# Rezoning Transportation Analysis

Petition Number: #2021-277

General Location Identifier: 15501125, 15501126

From: Jake Carpenter, PE

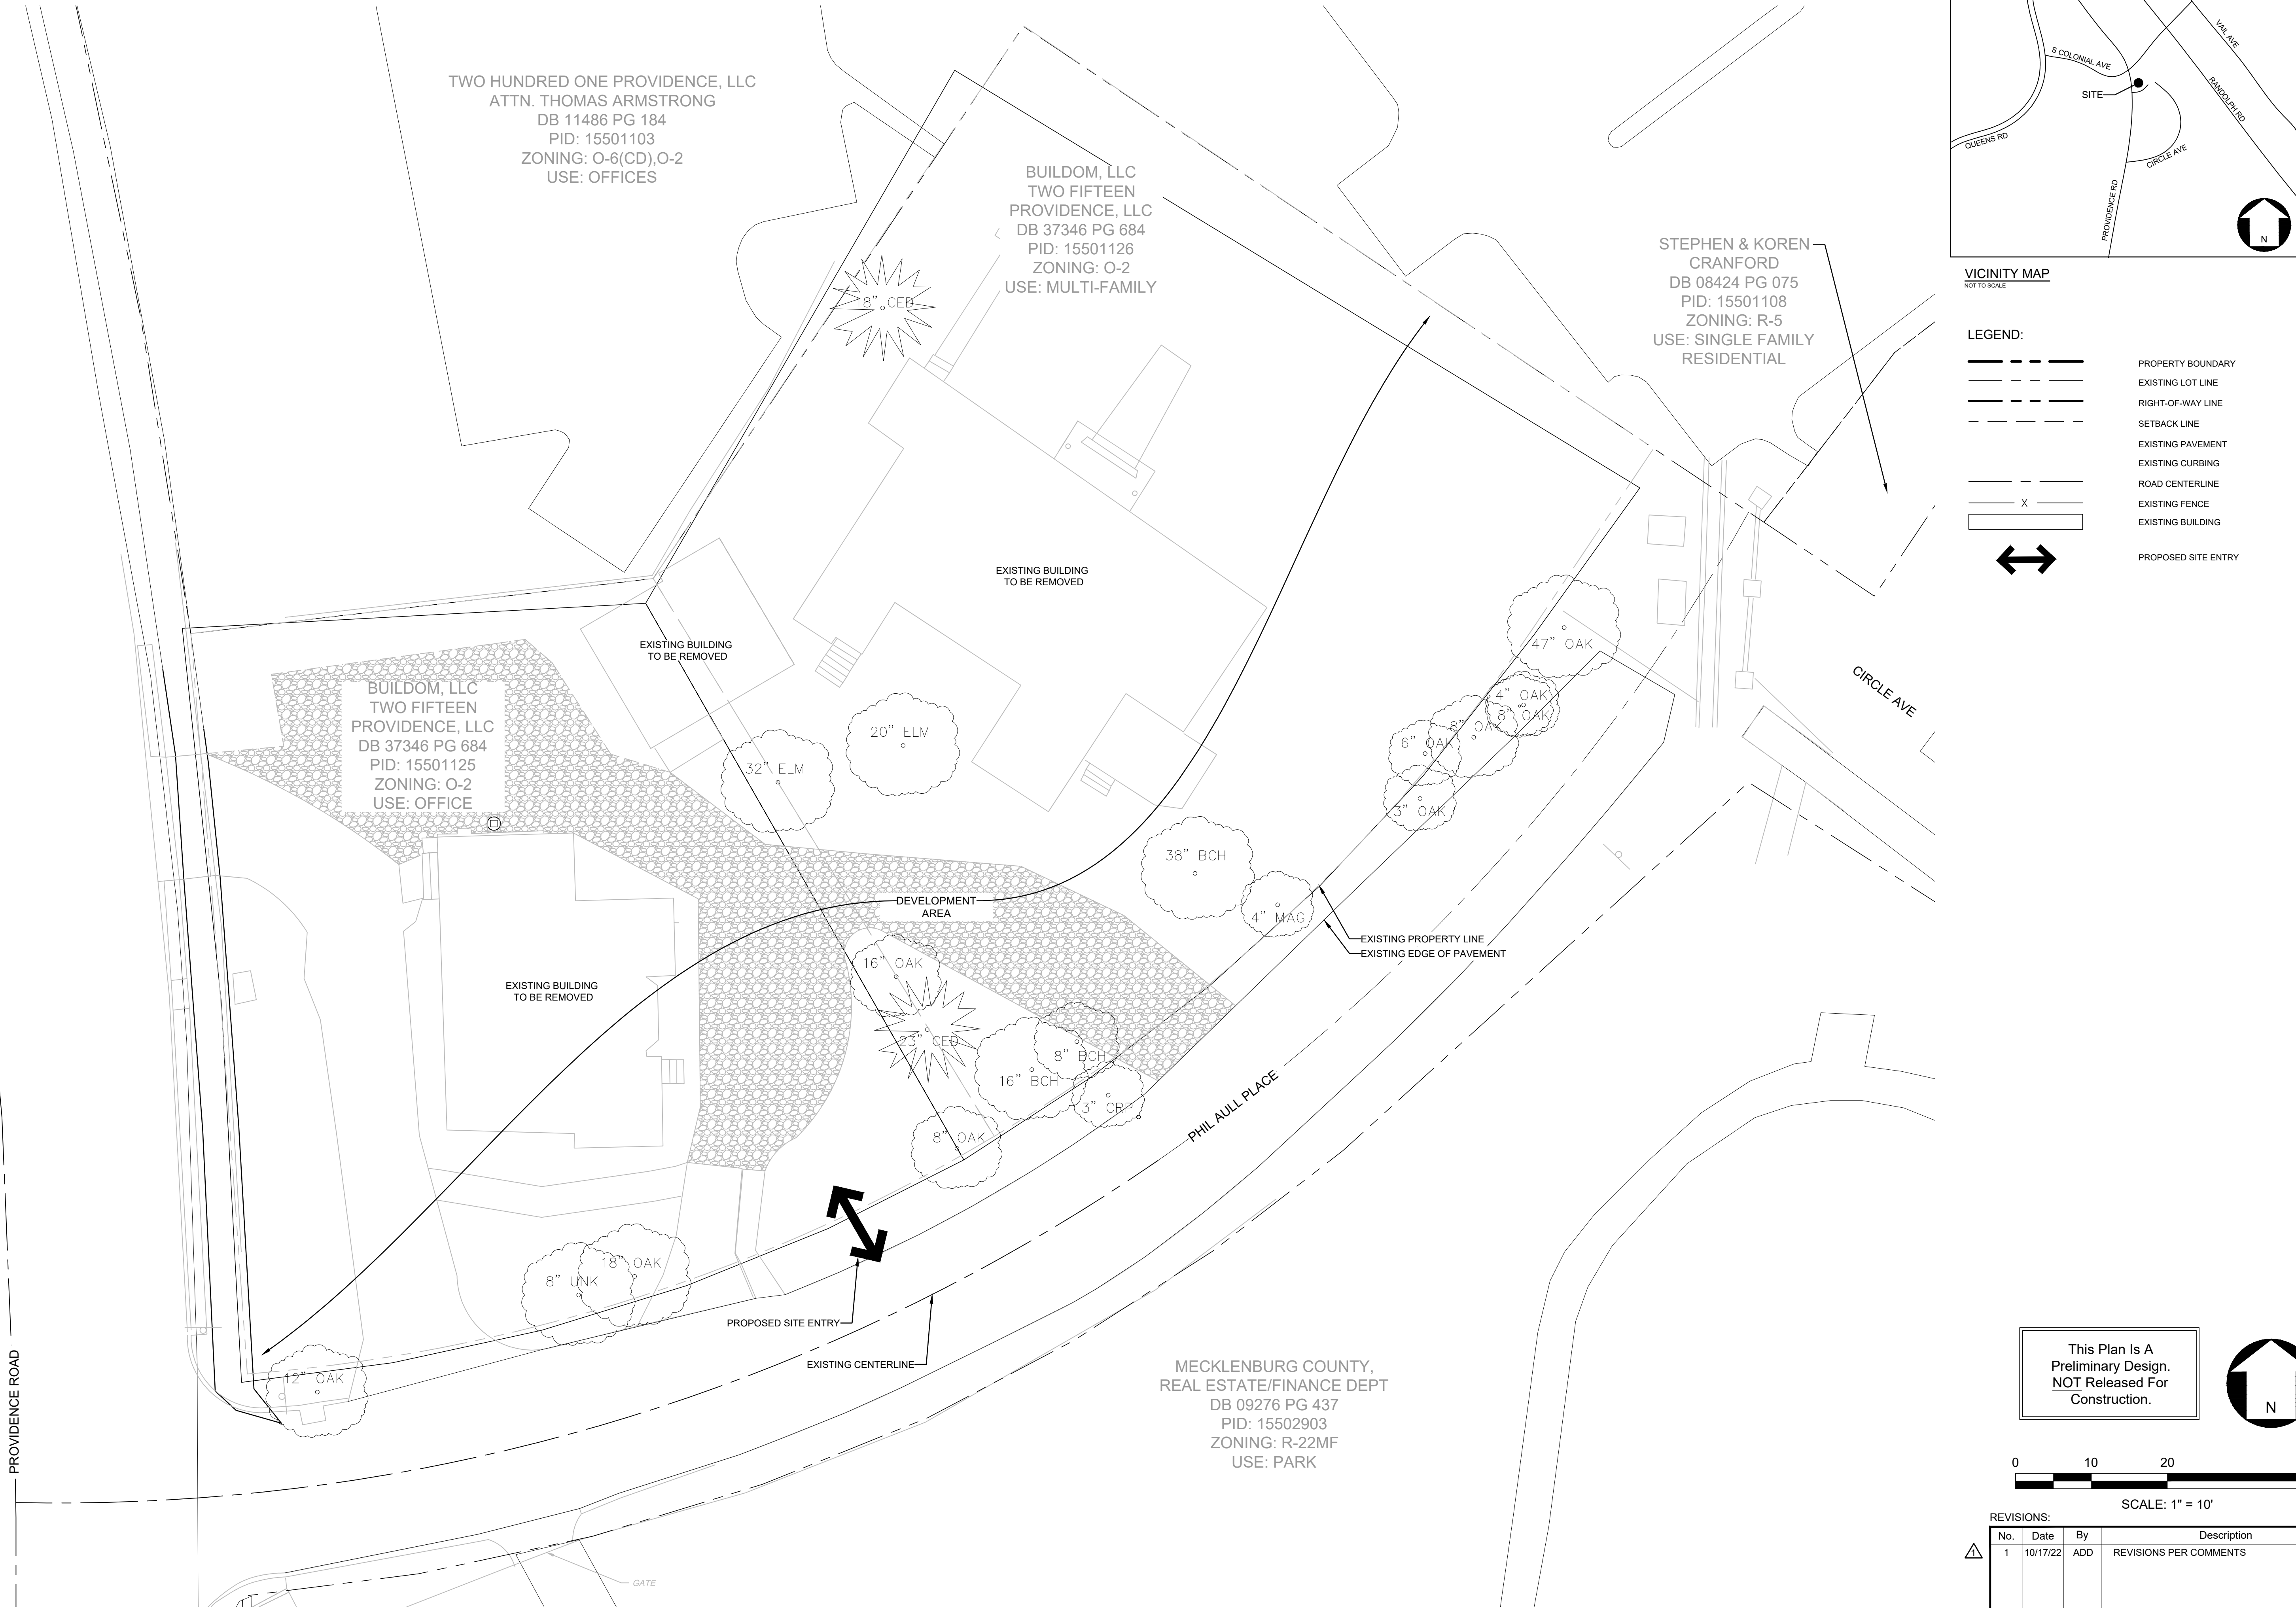
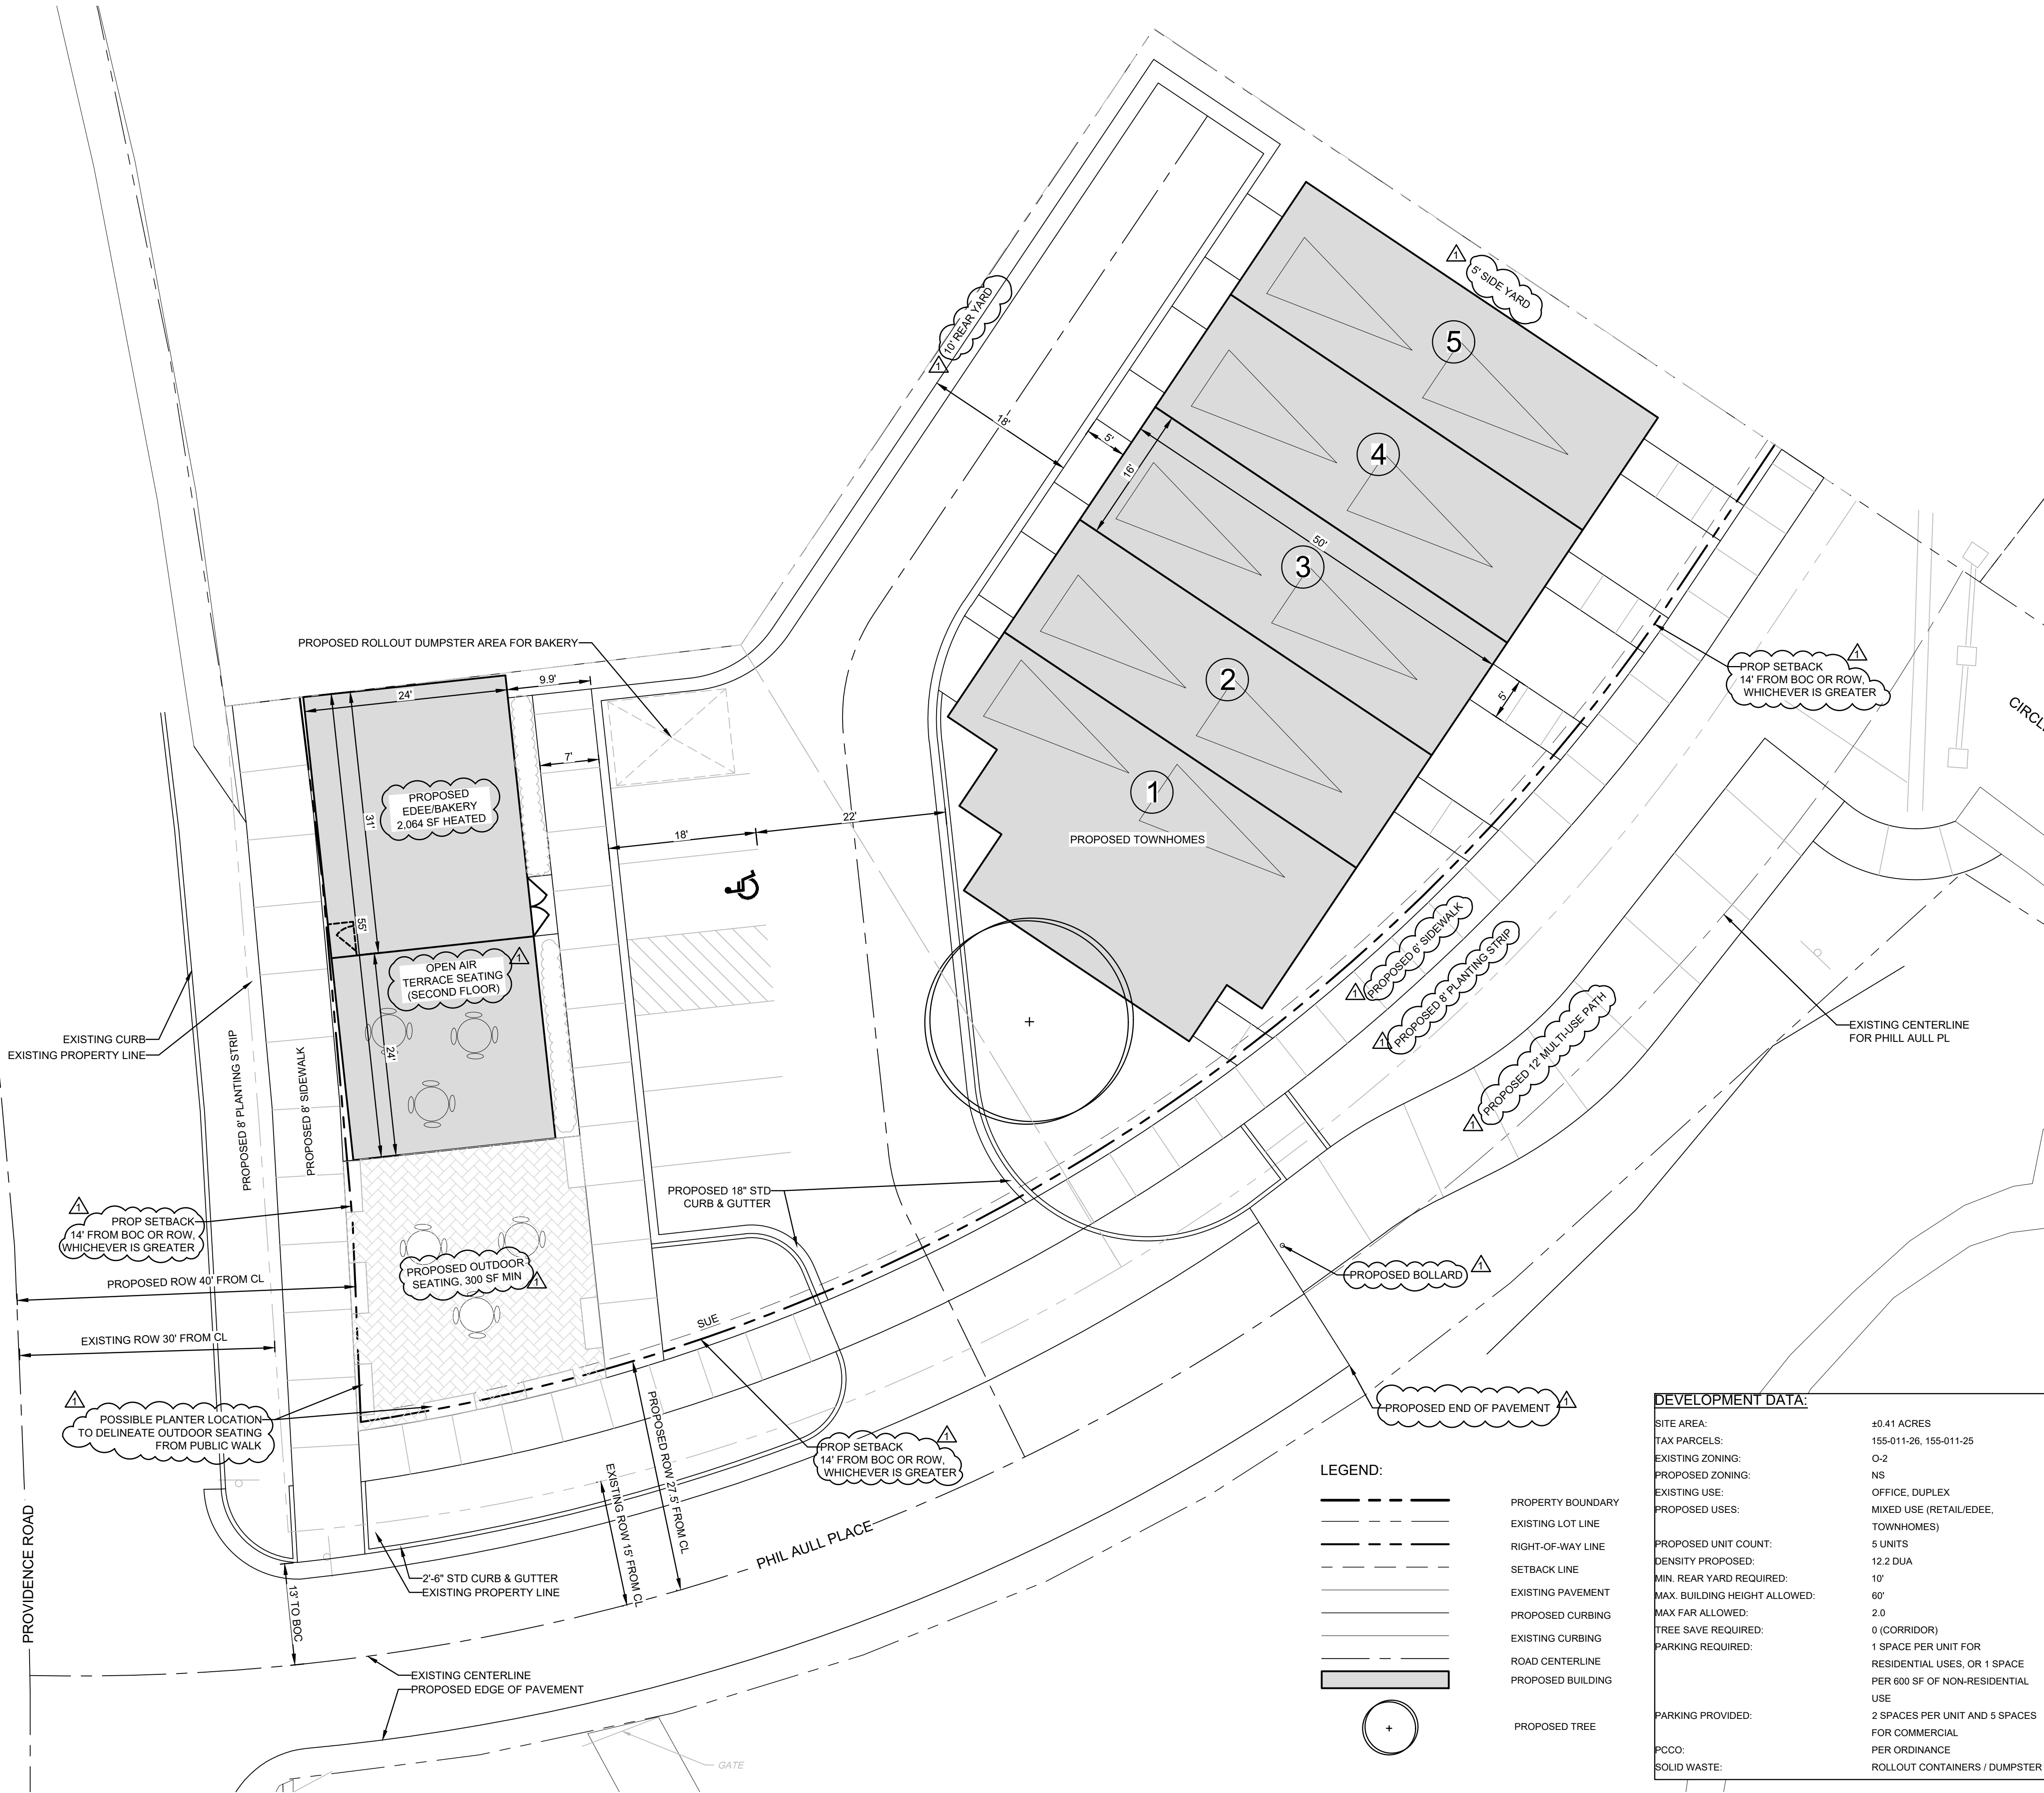
### 3. ~~Outstanding Comment from 5-18-22:~~ Revise site plan and conditional notes to commit to dedicate 40 ft (min) right-of-way from the Providence Road centerline. Provide a sidewalk utility easement (SUE) 2 ft behind the future back of sidewalk (50.5 ft from the centerline). The site plan shall label and dimension the right of way from the road centerline.

~~**Clarifying Comment from 10-26-2022:** Provide and show sidewalk utility easement (SUE) 2 ft behind the future back of sidewalk (50.5 ft from the centerline) on Providence Road.~~

6. ~~Outstanding Comment from 5-18-22:~~ Site plan and conditional notes revisions are needed to provide an ADA compliant pedestrian connection from Phill Aull Place to Circle Avenue.

~~Clarifying Comment 10-27-22:~~ Label and add conditional note committing to ADA compliant connection.
